CITY COUNCIL ZONING AGENDA ***Monday, May 19, 2014***

4. [Petition No. 2014-013](#) (Council District 7 - Driggs) by **Hawthorn Retirement, LLC** for a change in zoning for approximately 10.01 acres located on the east side of Providence Road between Lakeside Drive and Kuykendall Road from R-3 (single family residential) to INST(CD) (institutional, conditional).

CITY OF CHARLOTTE, MECKLENBERG COUNTY,
NORTH CAROLINA
REZONING PLAN
FOR
CHARLOTTE
TIREMENT RESIDENC
REZONING NOTES

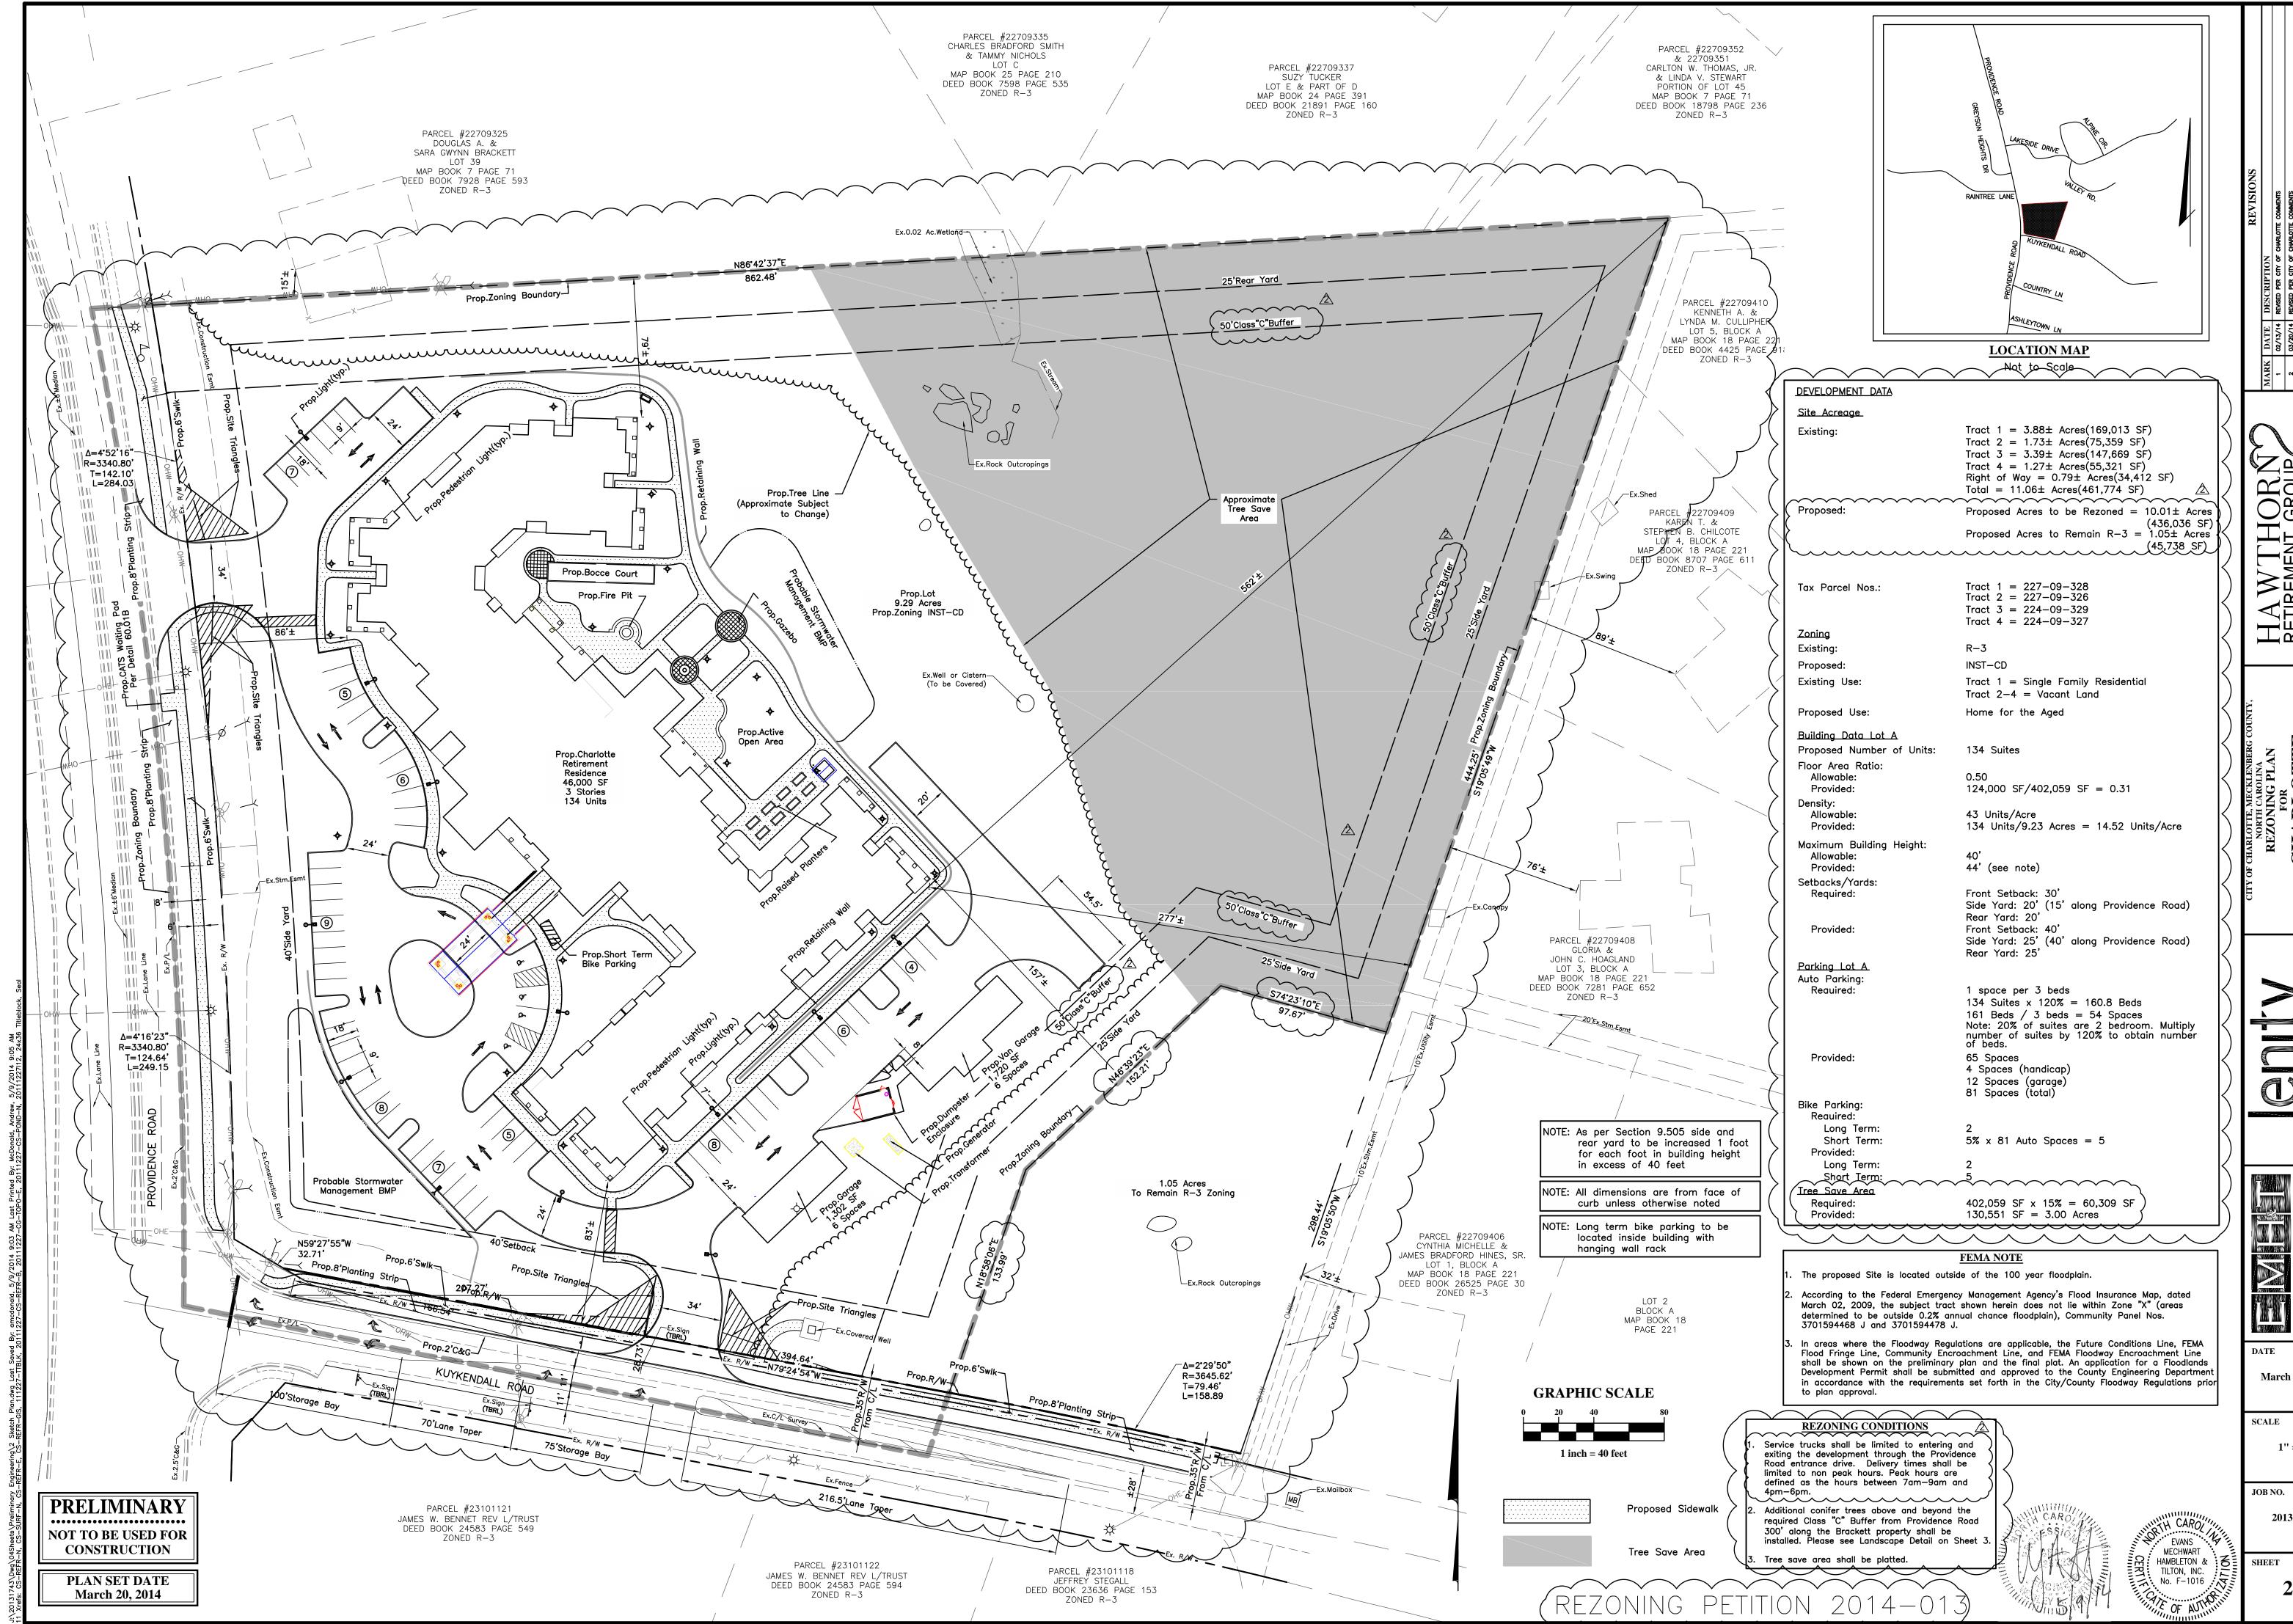
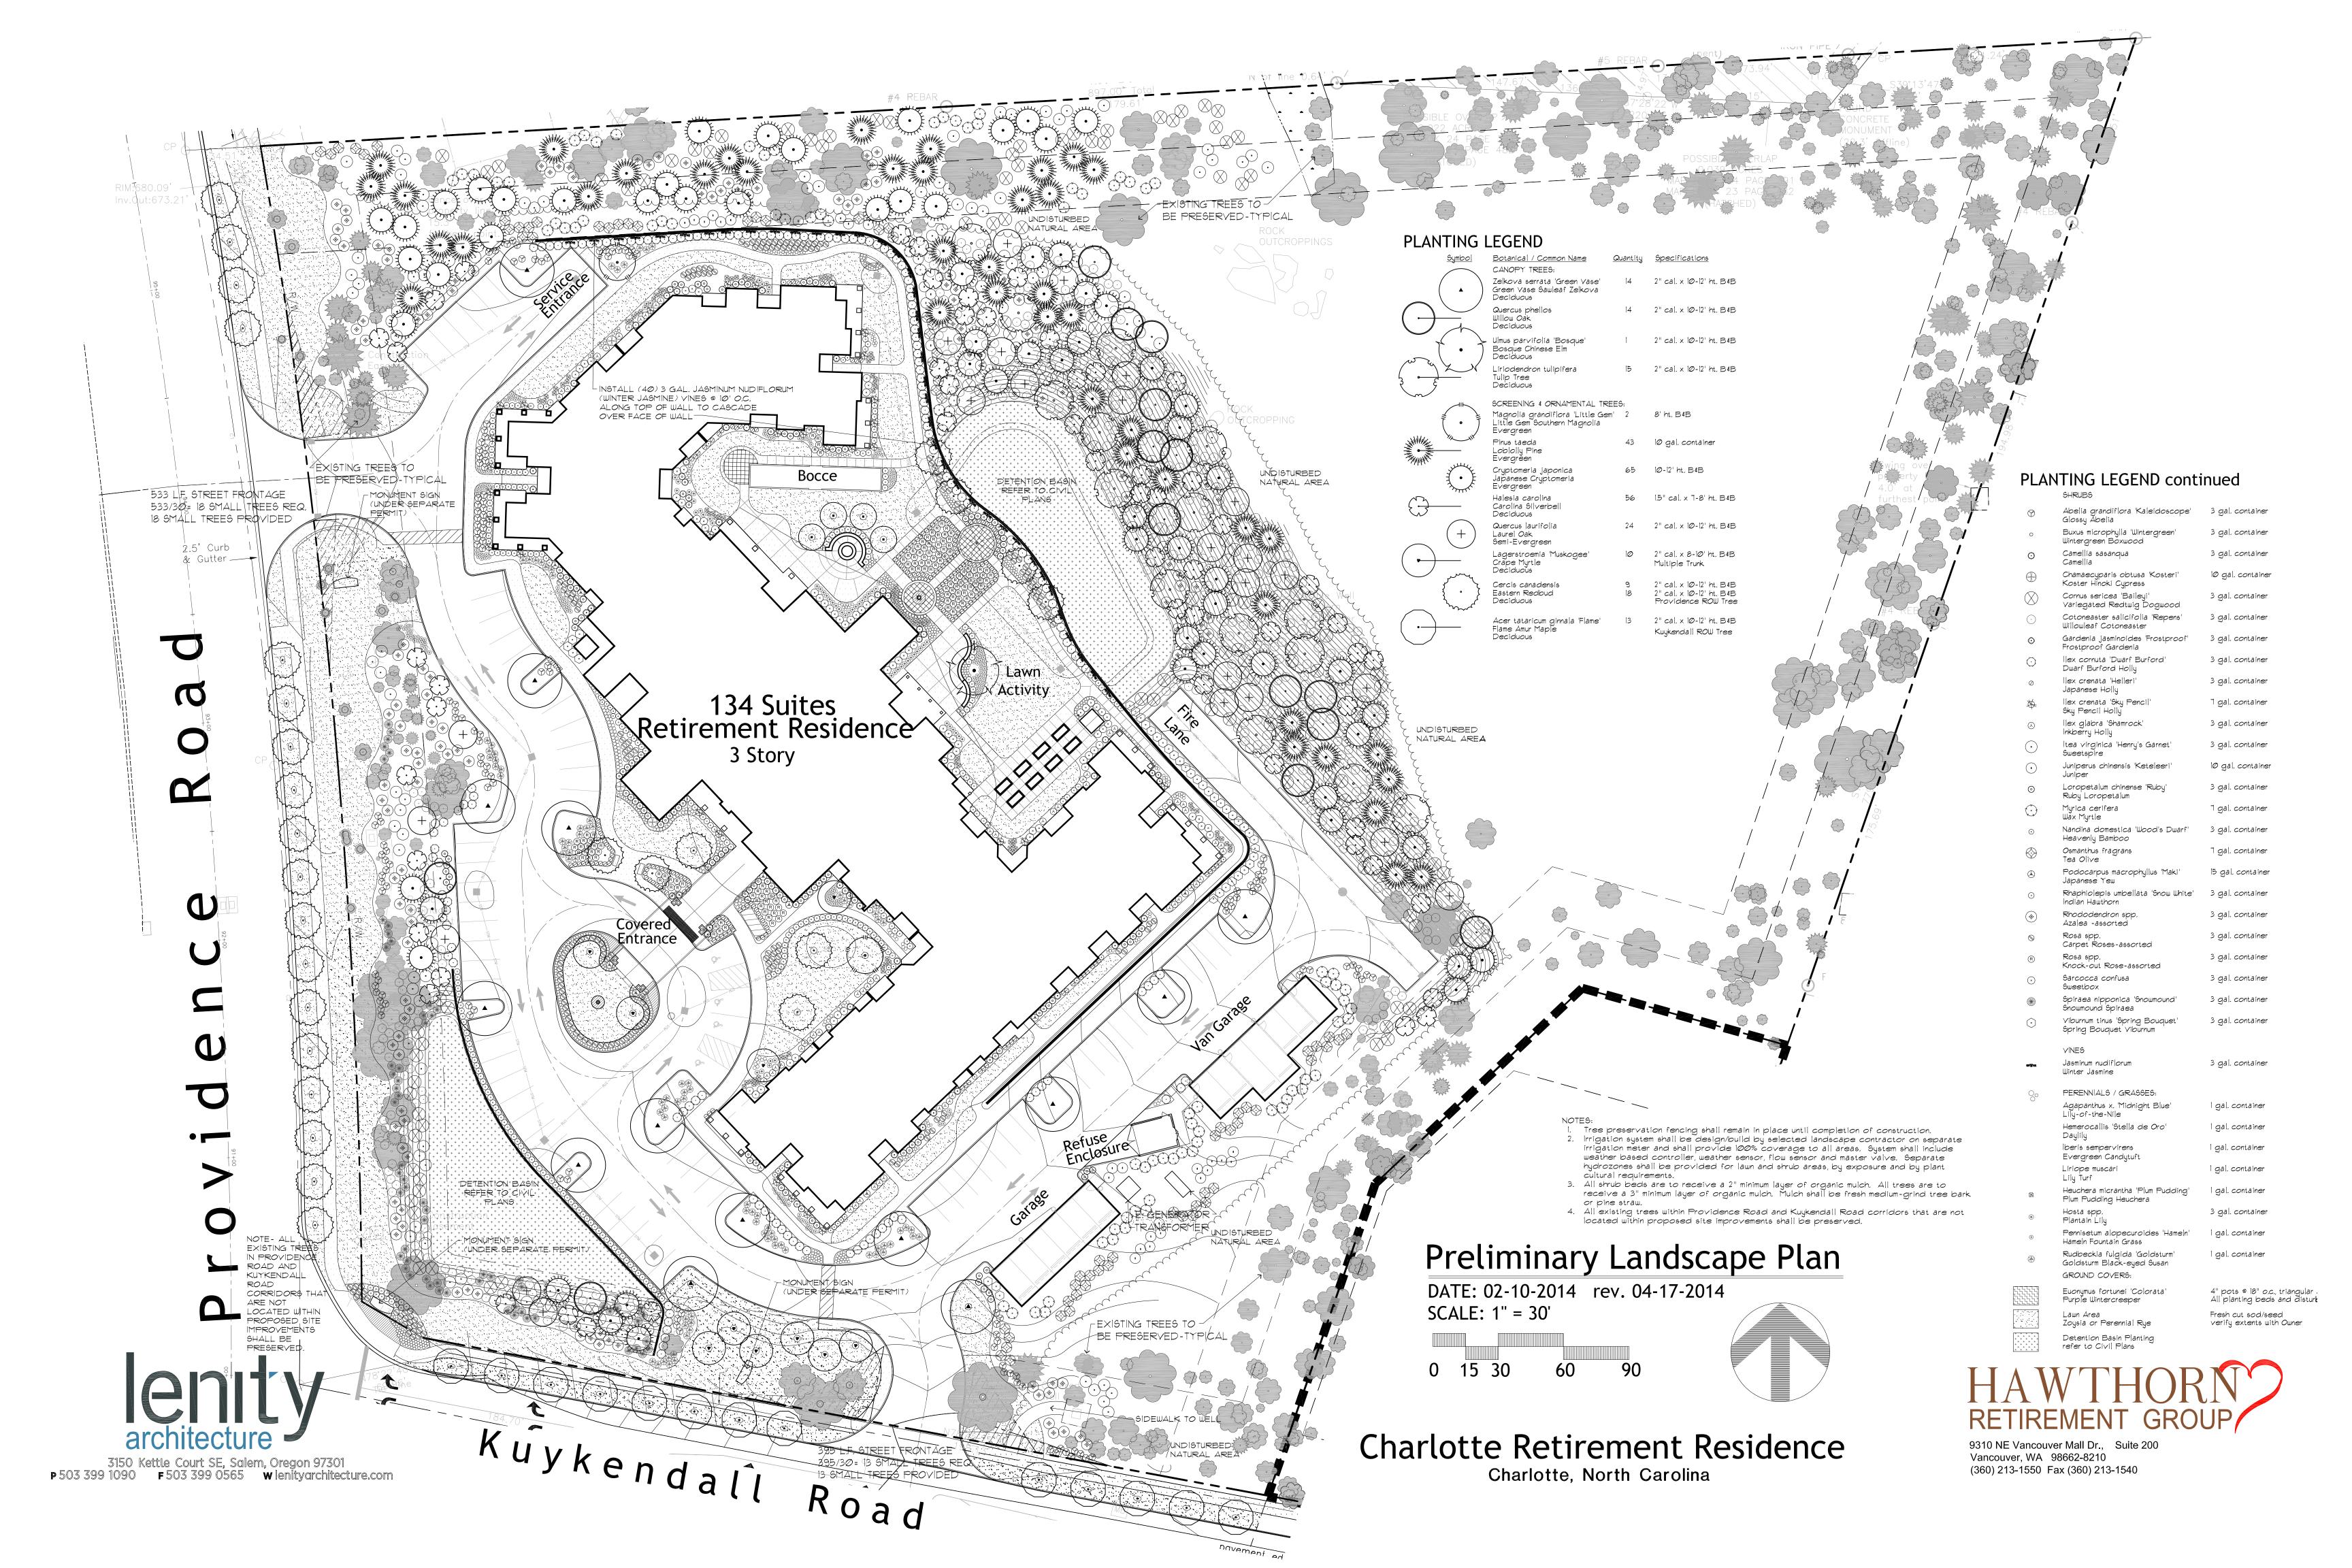
1. Amended note 2a to refer to Section 9.503 and specify the type of “Home for the Aged” units as dependent units. The petitioner added the following language for clarity, “except for the two independent units, for management staff only, not for rental purposes.”

2. Amended note 4a to specify a maximum proposed building height of 44 feet, which is more restrictive than the 45 feet requested by staff.
3. Placed an X over note 5c; the note will be removed completely with final plan submission.

4. Amended note 6a to reflect the amount of tree save provided as specified in the Development Data on sheet 2/3.
5. Provided additional building articulation and step downs along the southeastern and northern building façades.

6. Revised the Site Section A-A to reflect the current site design.
7. Deleted references to Lots A and B in the data table and amended site acreage under the data table to show the proposed acres to remain R-3 and proposed acres to be rezoned.

11. Added the required eight-foot planting strip along Providence Road to the Preliminary Landscape Plan.
12. Amended note 8a to limit the height of freestanding lights to 16 feet, which is more restrictive than the 20 feet requested by staff.

18. Amended site plan to reflect a required 50-foot Class C buffer instead of the 46-foot Class C buffer.
19. Removed unneeded sheets in the site plan packet.

20. Added note 8b for garage lighting.
21. Added overhang foliage to the retaining wall on the landscape plan and site sections.
